Re: Professional Engineer's Certification of Permanent Control Measure
Flying Horse North Filing No. 4, Pond B

This letter serves as a Pond Certification for the constructed Full Spectrum Detention Facility "Pond B" located in Flying Horse North Filing No. 4. The permanent control measure is located at the north central area of the subdivision and the northwestern part of the filing, adjacent and north of Old Stagecoach Road.

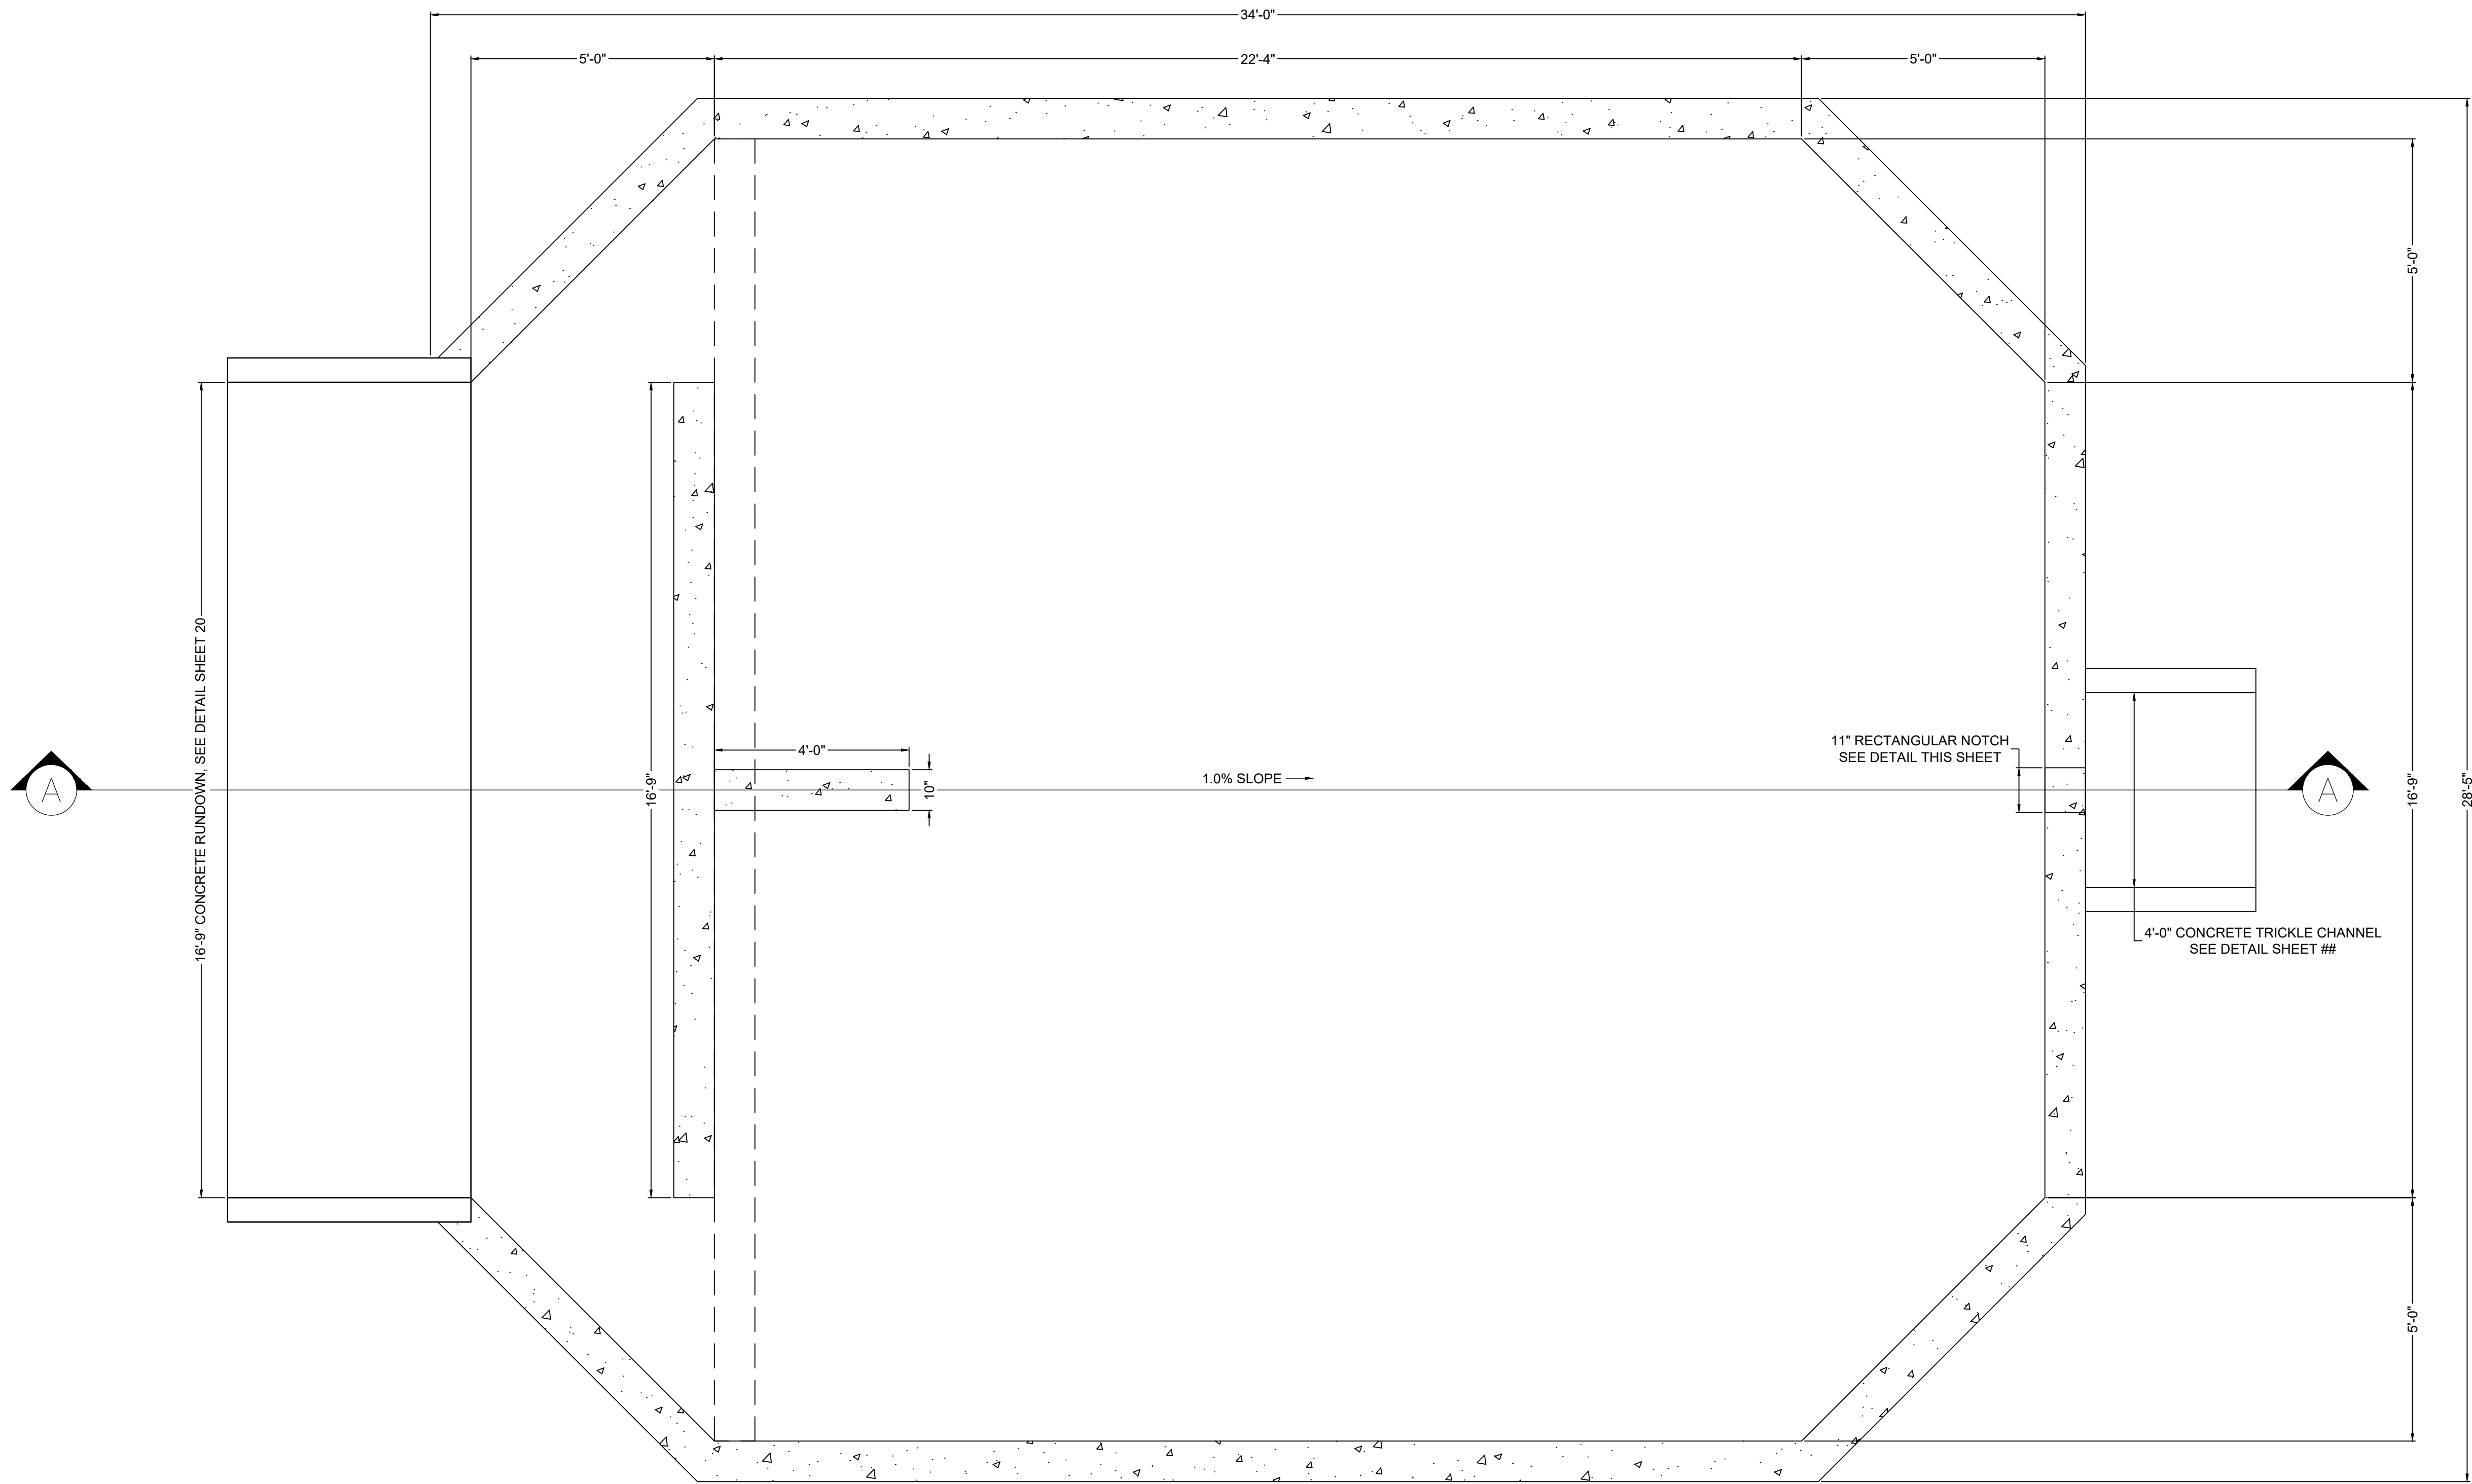
- "Ladder" steps are missing from micro pool. Install per approved plans. **Ladder steps installed to match Construction Drawings.**
- Outfall Riprap
 - Outfall riprap is not installed per the approved plans. Plans show buried riprap and in the field it is installed as exposed riprap. Install per approved plans or consult the Engineer of Record. See Note 1. **Outfall/spillway rip-rap is exposed rip-rap and is now reflected on the as-builts, as approved by the Engineer of Record.**
